March 11, 2021

Kittitas County Hearing Examiner
c/o Kelly Bacon, Staff Planner
Kittitas County Community Development Services
411 N Ruby ST, Suite 2
Ellensburg WA 98926
Email: kelly.bacon.cd@co.kittitas.wa.us

RE: COMMENTS ON STATE ENVIRONMENTAL POLICY ACT,
CONDITIONAL USE PERMIT – CU-20-00006-SWIFTWATER STORAGE

WLC PROPERTY HOLDINGS LLC
SITE PLAN

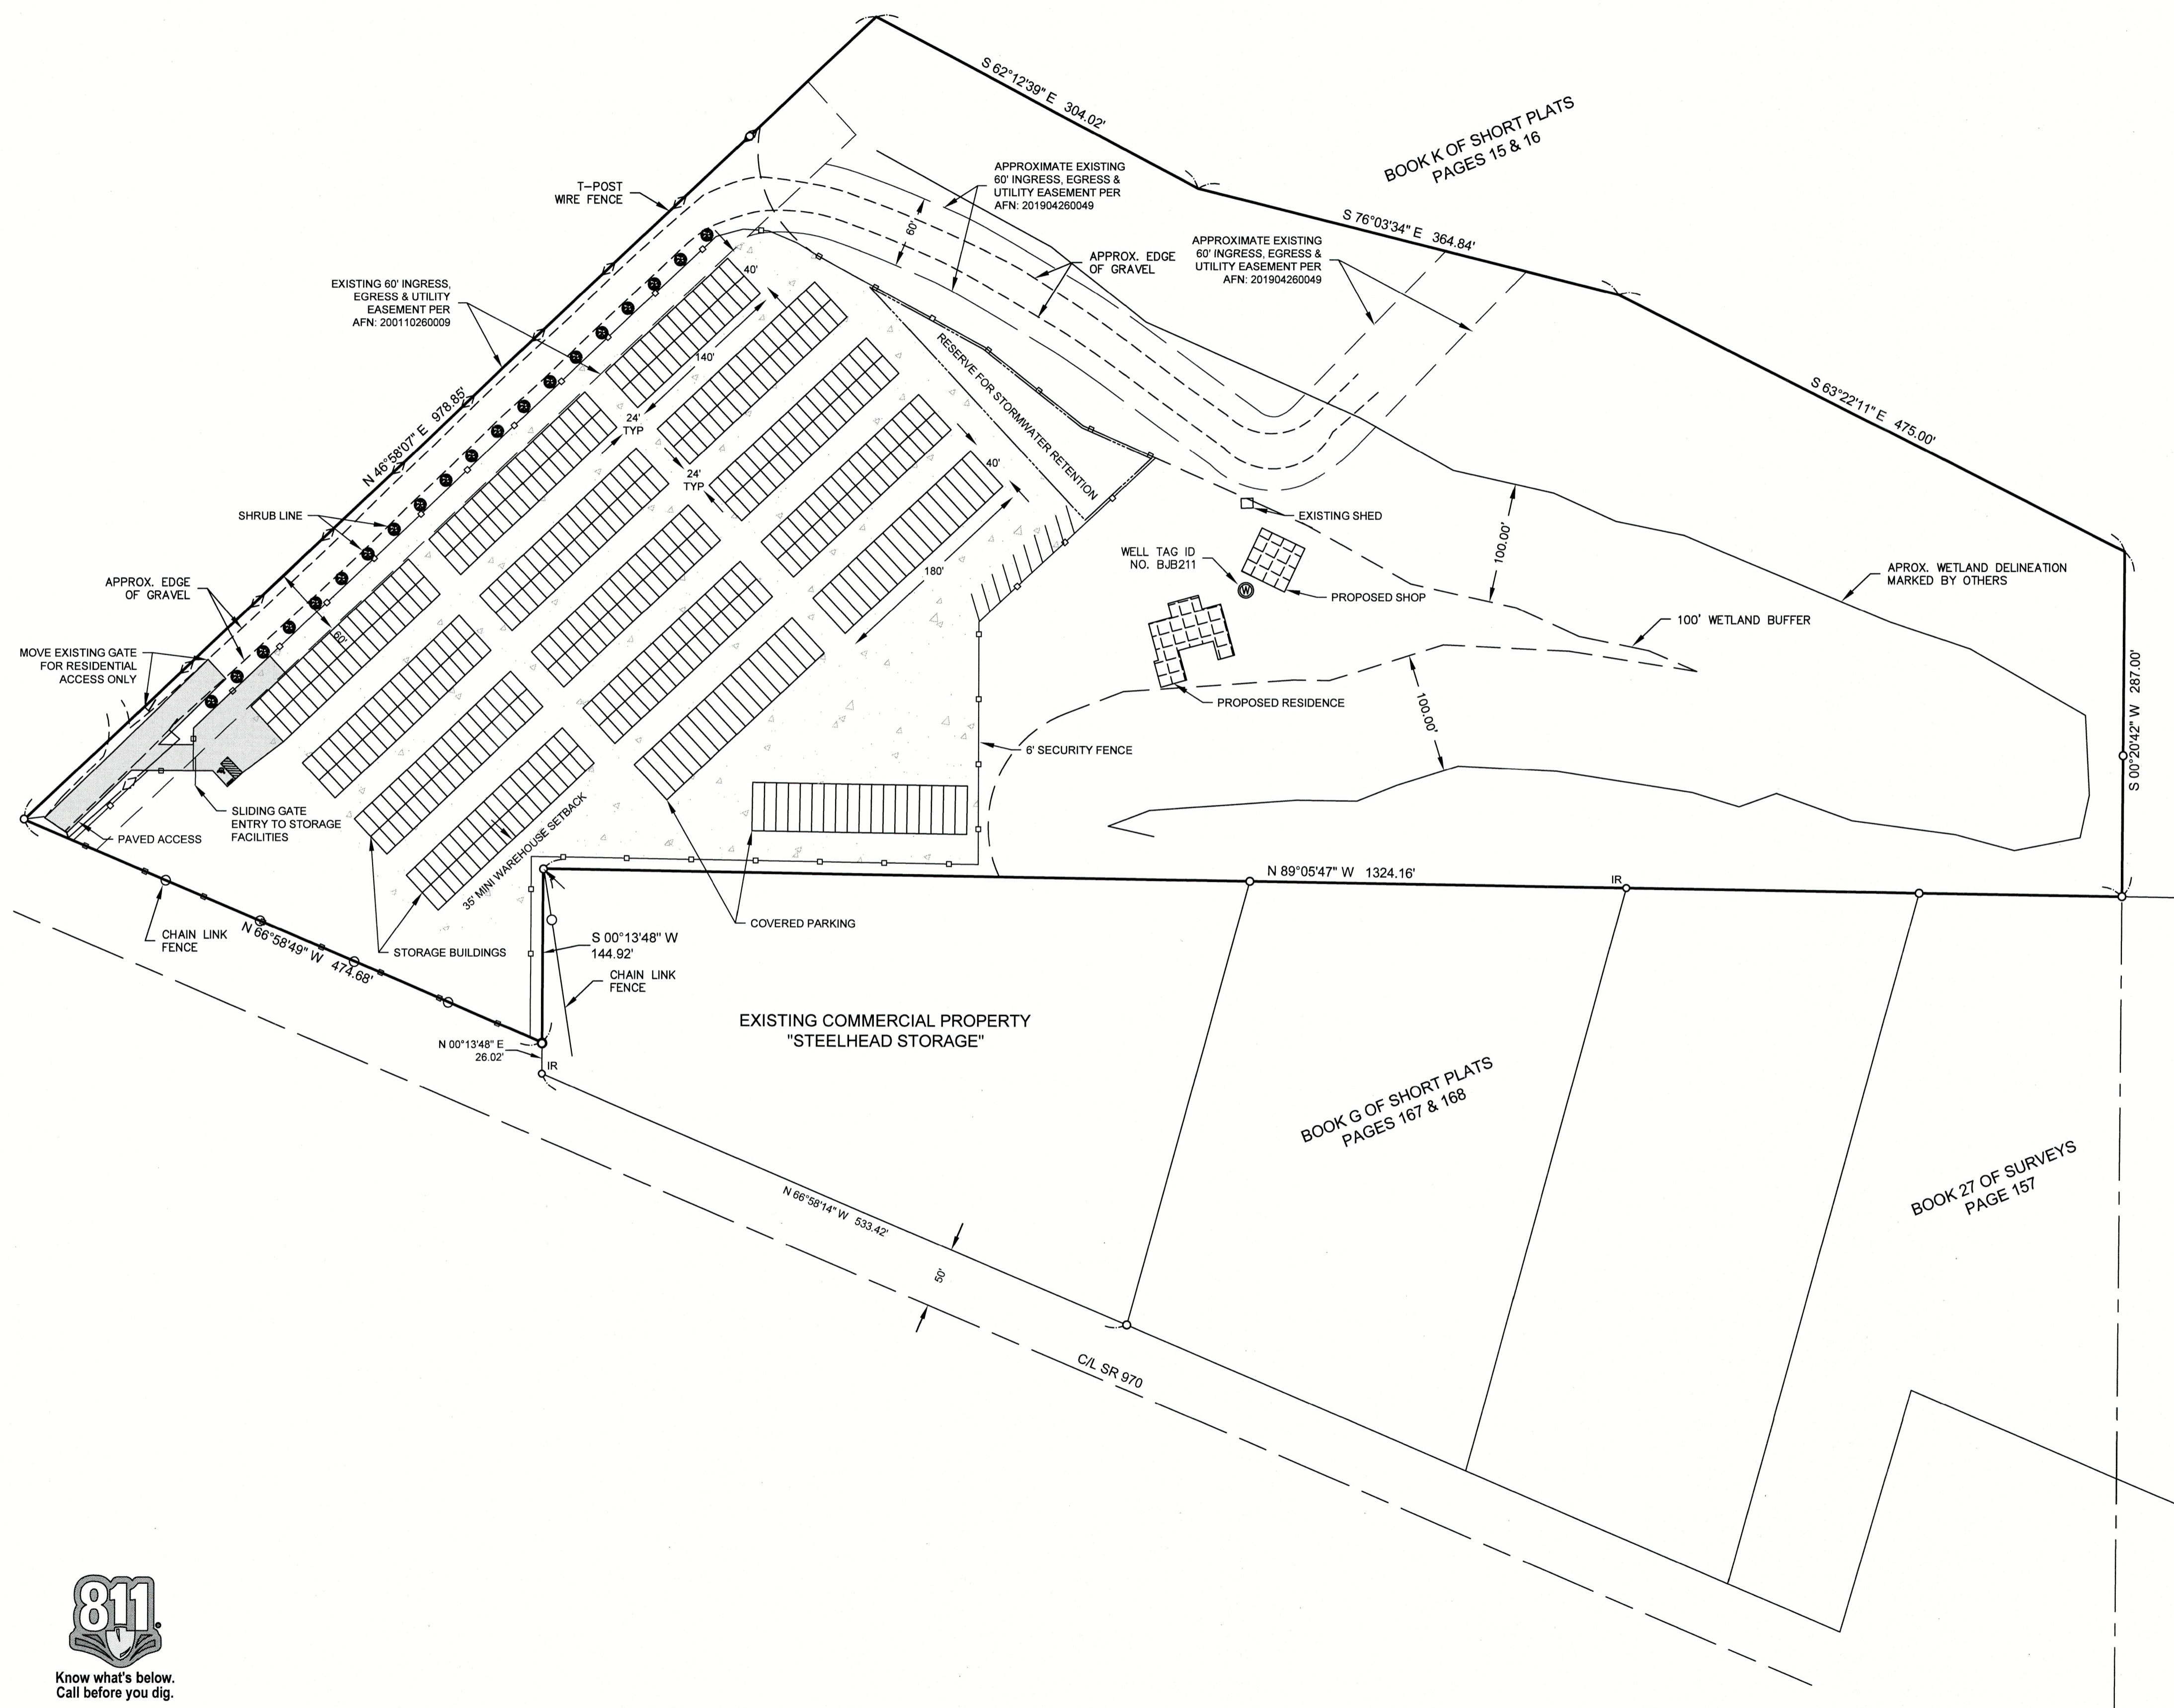
The project narrative for the conditional use permit describes an RV repair shop, septic for the shop, private restrooms with showers, and a public restroom. None of this is mentioned or included in the SEPA checklist or other documents. The septic drain fields for the house and RV repair shop also aren't shown on the site map, and their proximity to wetlands and streams. The location and design of the septic tanks and drain fields need to be provided for review.

The site plan map shows a narrow triangle piece of ground as "reserve for stormwater retention", but has no details or information on how or whether this will keep runoff from the storage facility from going into wetlands and streams. The plan needs to provide information on how they intend to capture, retain and infiltrate all stormwater runoff coming off the facility.
